# Outer Dowsing Offshore Wind

### Schedule of Changes to the Draft Development Consent Order

Date: December 2024

Document Reference: 3.1.1

Sheet 32

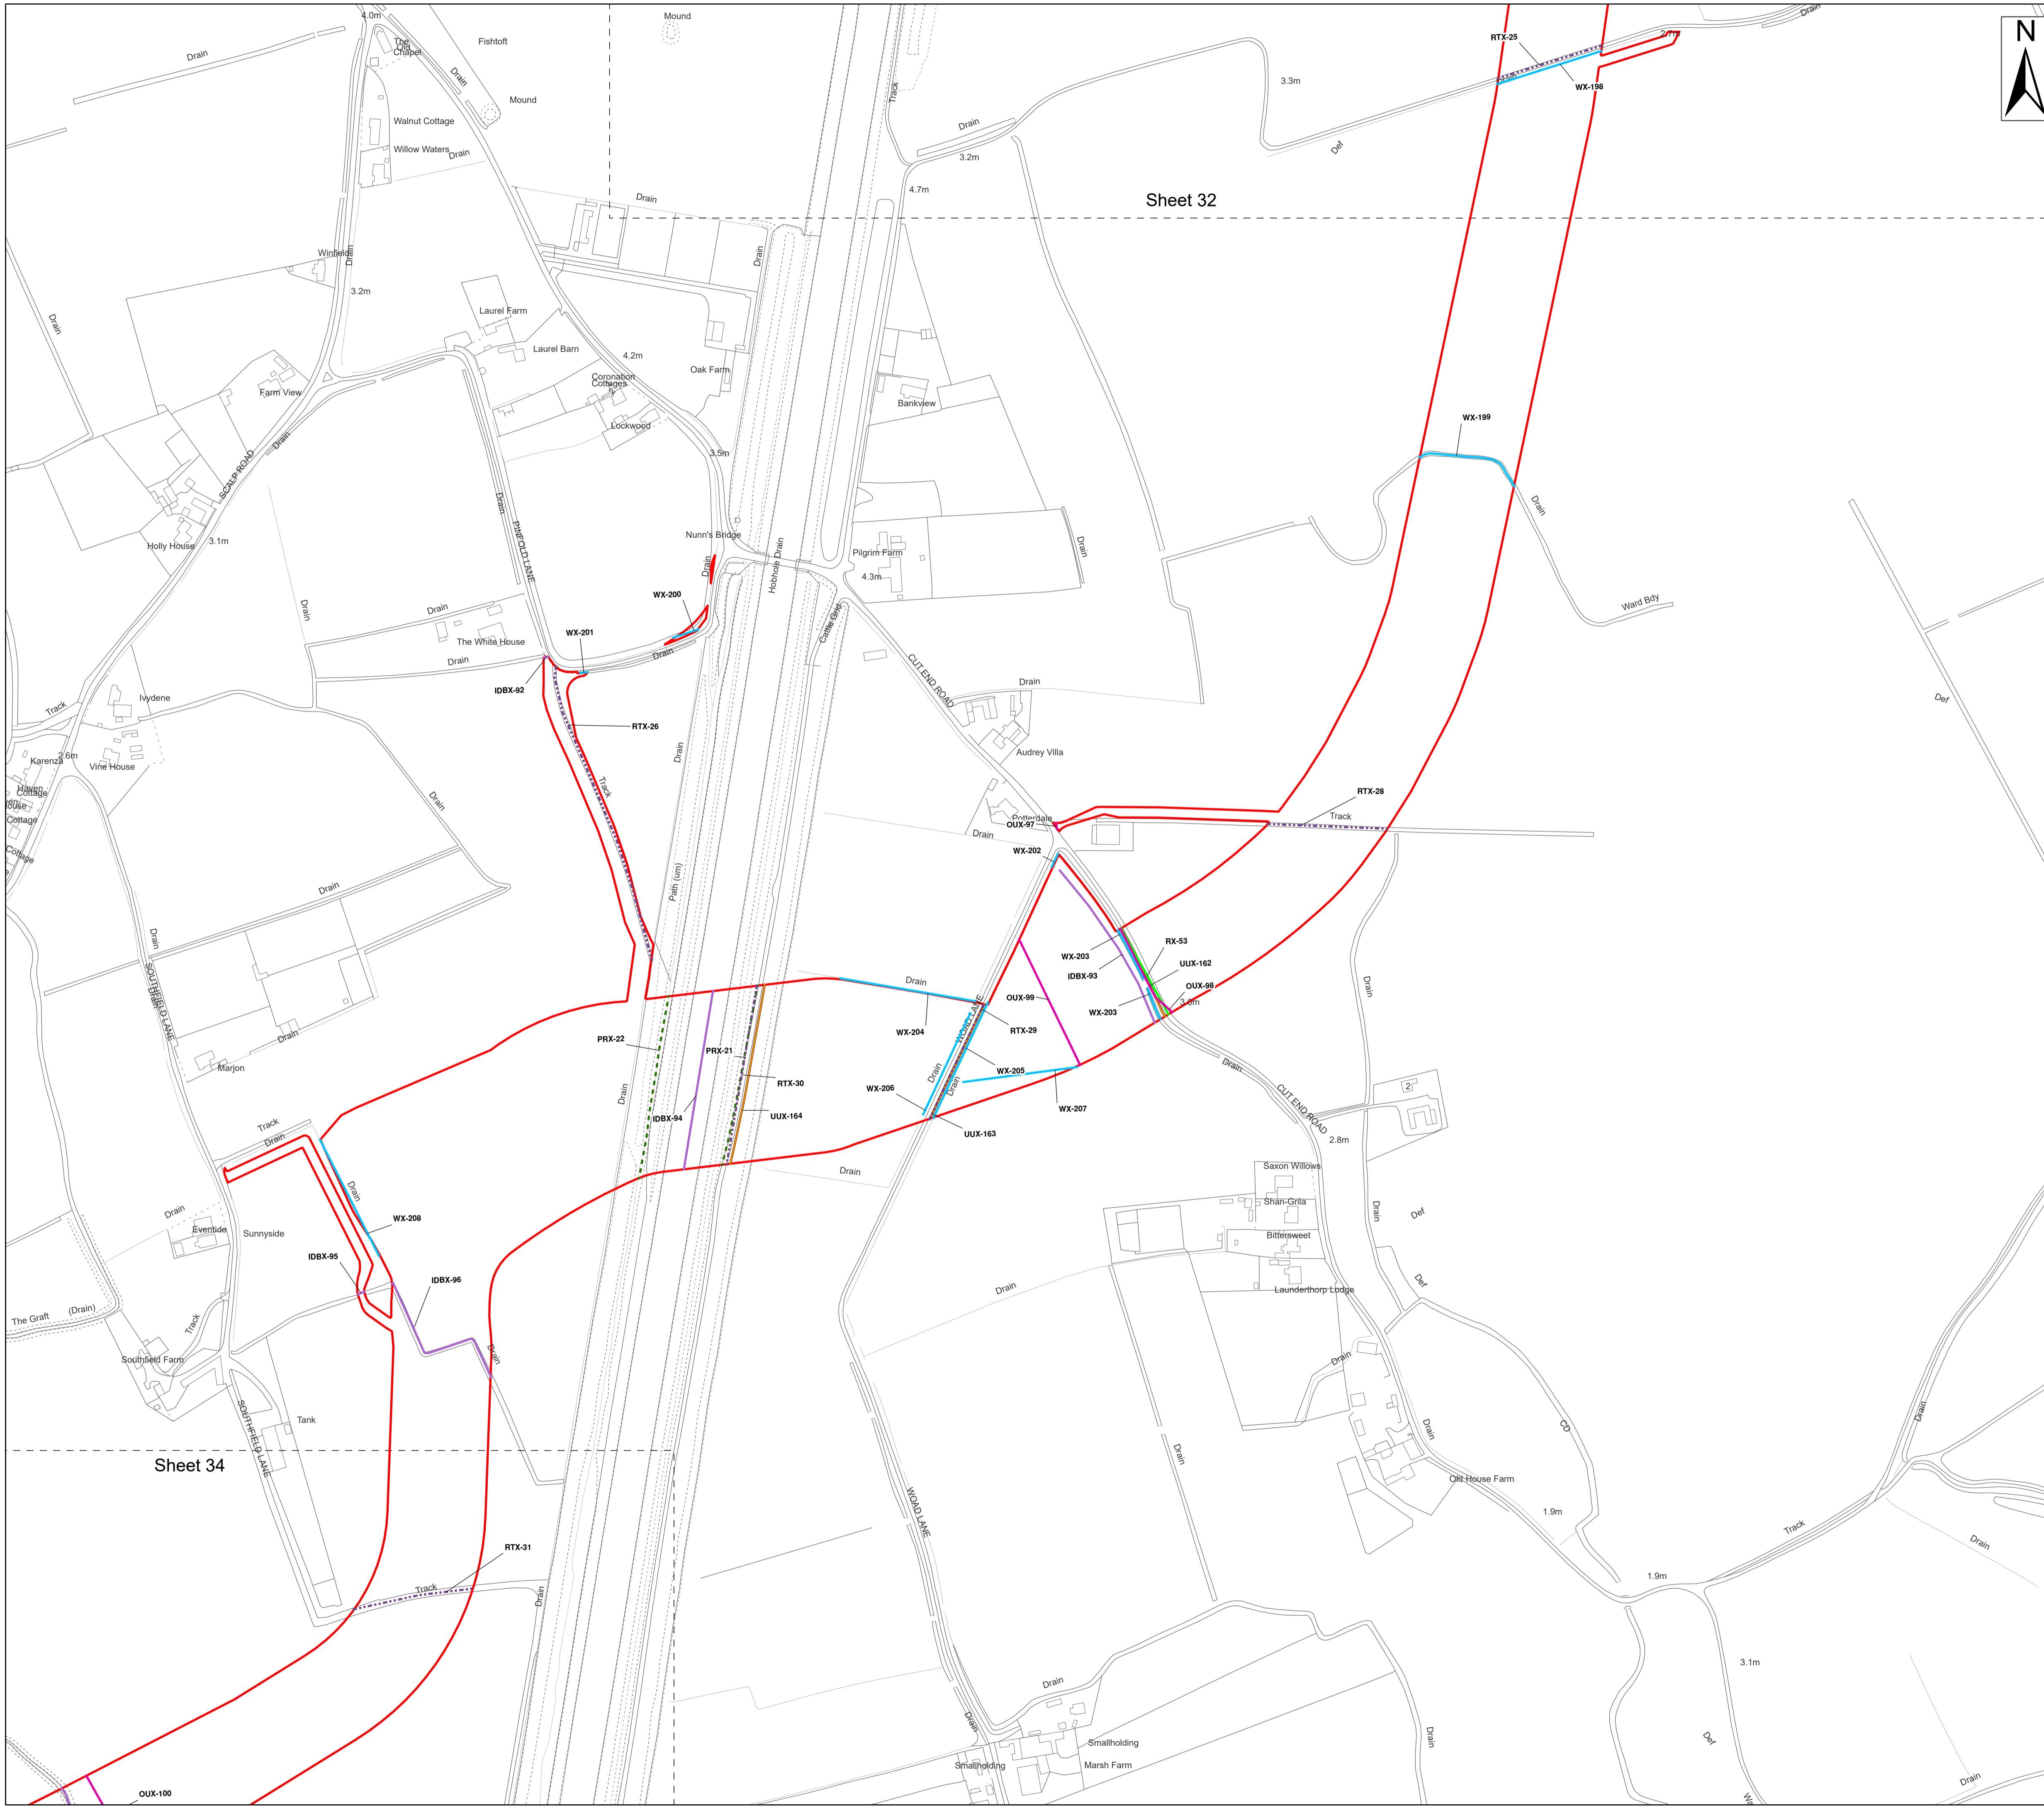
DCO Reference	Stakeholder	Comments from Stakeholder / Rationale for Change	Change Made		DCO Version		
		stop up and divert PRoWs apply in the event that these proposed PRoWs become PRoWs.	Boston Borough Council	Proposed Public Footpath, (B/24/0197)	<p><i>temporary diversion, planning application reference B/24/0197, shown by a pink line between points CTD9 and CTD10 and marked B/24/0197, on sheets 31 and 32 of the public rights of way plan.</i></p> <p><i>Approximately 180m of the proposed Public Footpath, to be Closed - temporary diversion, planning application reference B/24/0197, shown by a pink line between points CTD11 and CTD12 and</i></p>	<p><i>the public rights of way plan.</i></p> <p><i>Approximately 165m diversion shown by a blue line on sheet 32 of the public rights of way plan.</i></p>

DCO Reference	Stakeholder	Comments from Stakeholder / Rationale for Change	Change Made				DCO Version
				<p><i>marked B/24/0197, on sheet 32 of the public rights of way plan.</i></p> <p><i>Boston Borough Council</i></p> <p><i>Proposed Public Footpath, (B/24/0198)</i></p>	<p><i>Approximately 75m of the proposed Public Footpath, to be Closed - temporary diversion, planning application reference B/24/0198, shown by a pink line and marked B/24/0198, on sheets 32 and 33 of the public rights of way plan.</i></p>	<p><i>Approximately 82m diversion shown by a blue line on sheets 32 and 33 of the public rights of way plan.</i></p>	
Schedule 3	Applicant, LCC	The Applicant no longer intends to proceed with the inclusion of the proposed public rights of way identified for inclusion at Version 3 above. These proposed public rights of way have therefore been removed from Schedule 3.	(1) Area  [...]	(2) Public right of way to be temporarily stopped up	(3) Extent of temporary stopping up	(4) Temporary public right of way to be substituted	5

DCO Reference	Stakeholder	Comments from Stakeholder / Rationale for Change	Change Made				DCO Version
			<del>Boston Borough Council</del>	<del>Proposed Public Footpath, (B/24/0197)</del>	<del>Approximately 134m of the proposed Public Footpath, to be Closed – temporary diversion, planning application reference B/24/0197, shown by a pink line between points CTD9 and CTD10 and marked B/24/0197, on sheets 31 and 32 of the public rights of way plan.</del>	<del>Approximately 240m diversion shown by a blue line on sheets 31 and 32 of the public rights of way plan.</del>	
			Boston Borough Council	Proposed Public Footpath, (B/24/0197)	Approximately 180m of the proposed Public Footpath, to be Closed – temporary diversion, planning application reference	Approximately 165m diversion shown by a blue line on sheet 32 of the public rights of way plan.

DCO Reference	Stakeholder	Comments from Stakeholder / Rationale for Change	Change Made		DCO Version		
			<i>Boston Borough Council</i>	<i>Proposed Public Footpath, (B/24/0198)</i>	<p><i>B/24/0197, shown by a pink line between points CTD11 and CTD12 and marked B/24/0197, on sheet 32 of the public rights of way plan.</i></p> <p><i>Approximately 75m of the proposed Public Footpath, to be Closed - temporary diversion, planning application reference B/24/0198, shown by a pink line and marked B/24/0198, on sheets 32 and 33 of the public rights of way plan.</i></p>	<p><i>Approximately 82m diversion shown by a blue line on sheets 32 and 33 of the public rights of way plan.</i></p>	
<b>Schedule 7 - Land in which only new rights etc. may be acquired</b>
